From: Simon Davis
Sent: 10 July 2018 15:11
To: Planning.Responses
Subject: FW: 97 Barnham Road, Eastergate - EG/107/17/DOC

Number
S17-03-01 E

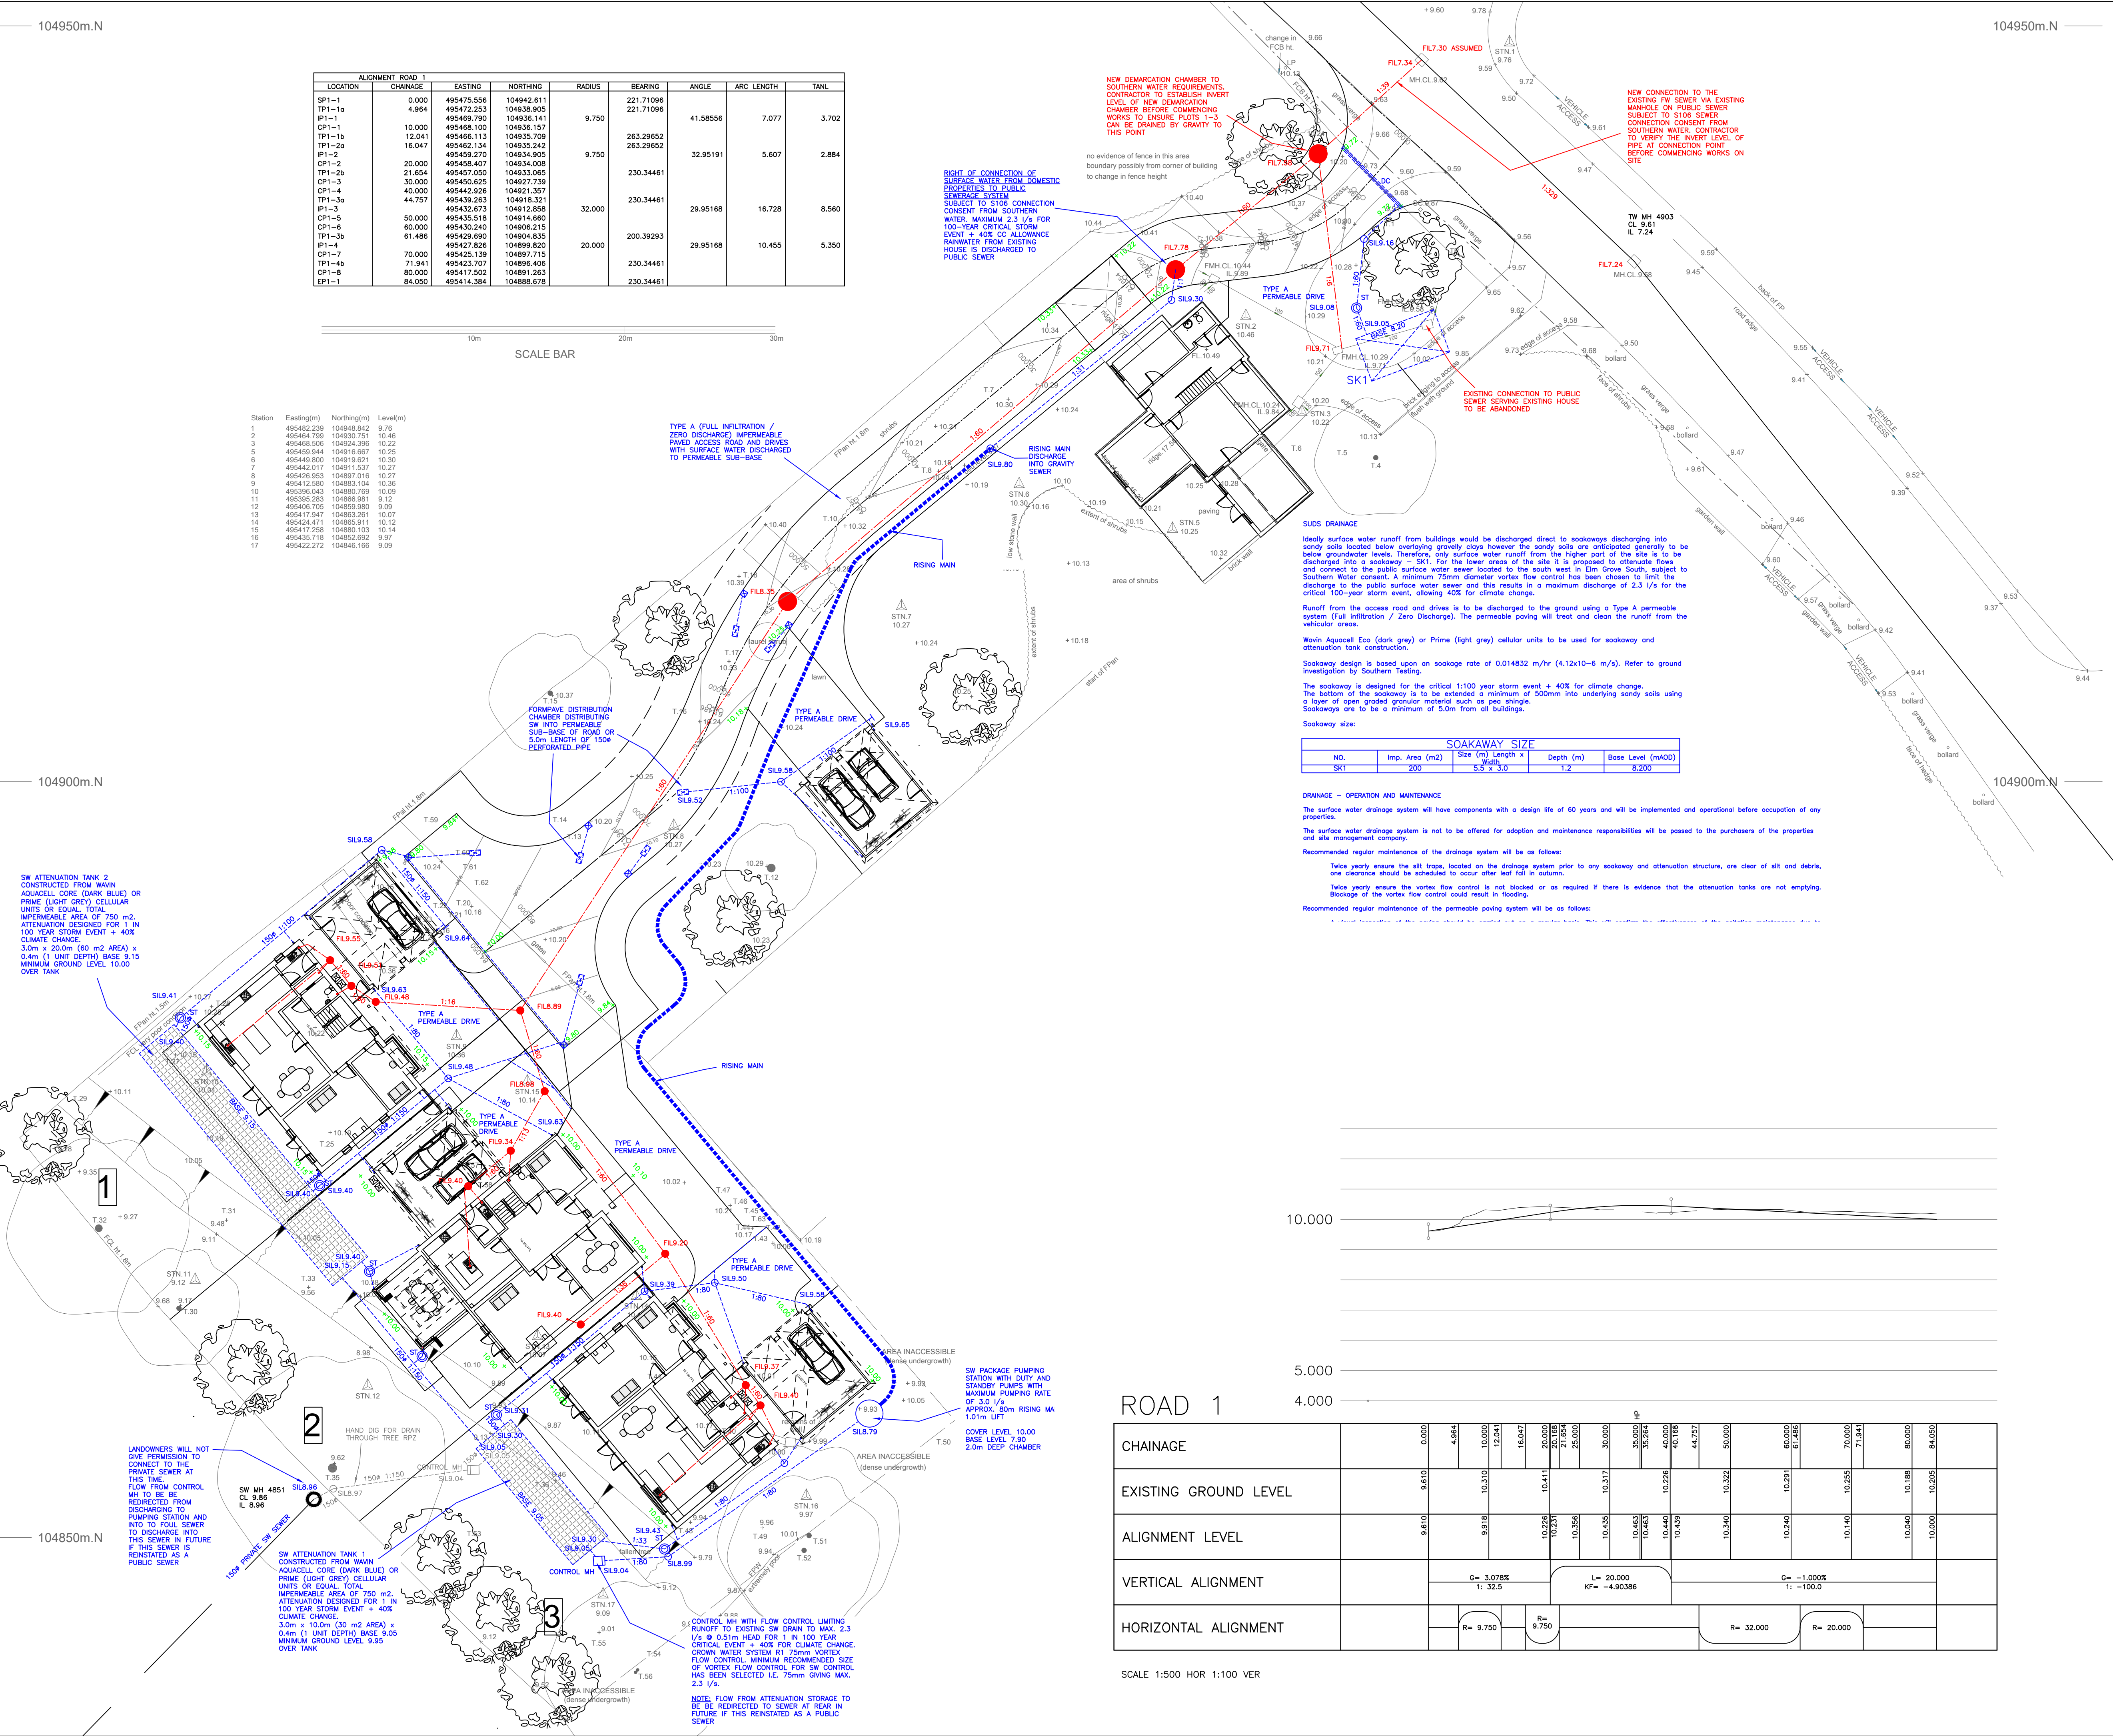
As stated in the letter the flows from the surface water far surpass the foul water flow, the surface water is being pumped into the foul main. The length of gravity sewer is required to slow this flow down so that flow velocity discrepancies between foul and surface water are far less. Therefore reducing the risk of backing up, damage to the pipe, and blockages.

However, we need to see an additional manhole and length of gravity pipe (to be laid at an agreed gradient) at the downstream extent of the rising main. Not including this could result in serious problems with backing up of foul water and blockages occurring as a result.
